Consultation Response from KC Highways
2019/91239 The Shears, 201, Halifax Road, Hightown, Liversedge, WF15 6NR
Demolition of existing public house and erection of four dwellings
Date
Responded:09/05/2019
Responding Officer:MB
Responding Ref:9-4NE-4

This application seeks approval to the demolition of an existing public house and the erection of 4 detached dwellings at The Shears, 201, Halifax Road, Hightown, Liversedge.

HALIFAX ROAD

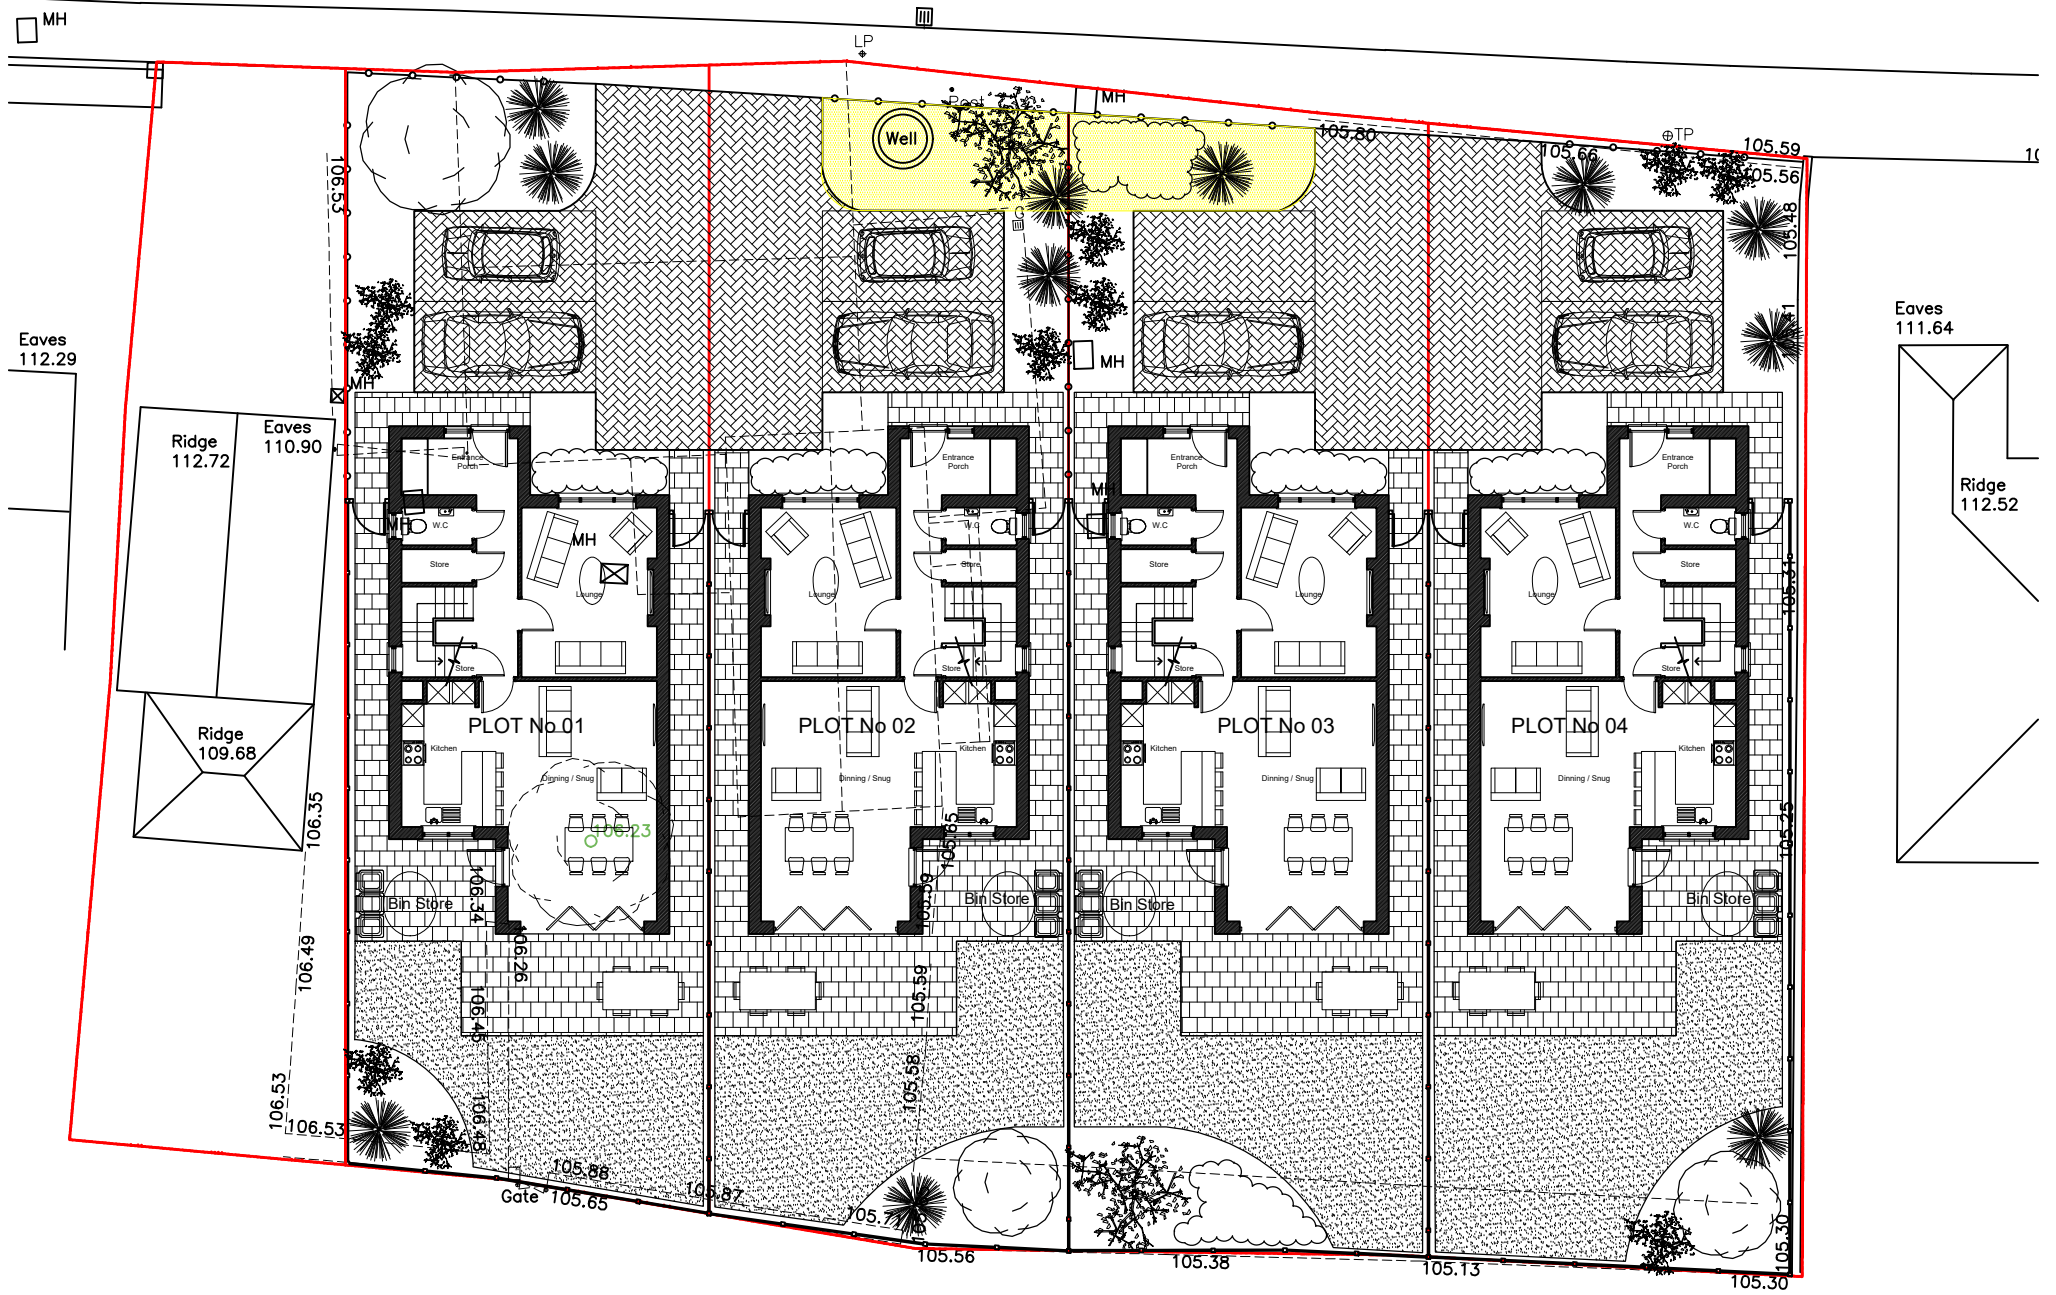
Each of the 4 dwellings has a driveway with parking for 2 vehicles and access directly onto Halifax Road.

The existing footway to the site frontage varies in width. Scaling from the plans the width varies from between 0.9m and 2.3m.

1,Given the size of the dwellings and that they are all 4 bedroomed 3 off-street parking spaces should be provided.

2,The width of the proposed driveways is only 4 metres which is insufficient to allow vehicles to turn into and out of the proposed parking spaces.

3,No bin collection points are shown to be provided.

4,The width of the existing footway should be widened to a minimum of 2.0m to the full site frontage. This will improve sight lines from the proposed driveways onto Halifax Road and pedestrian facilities along this section of Halifax Road.
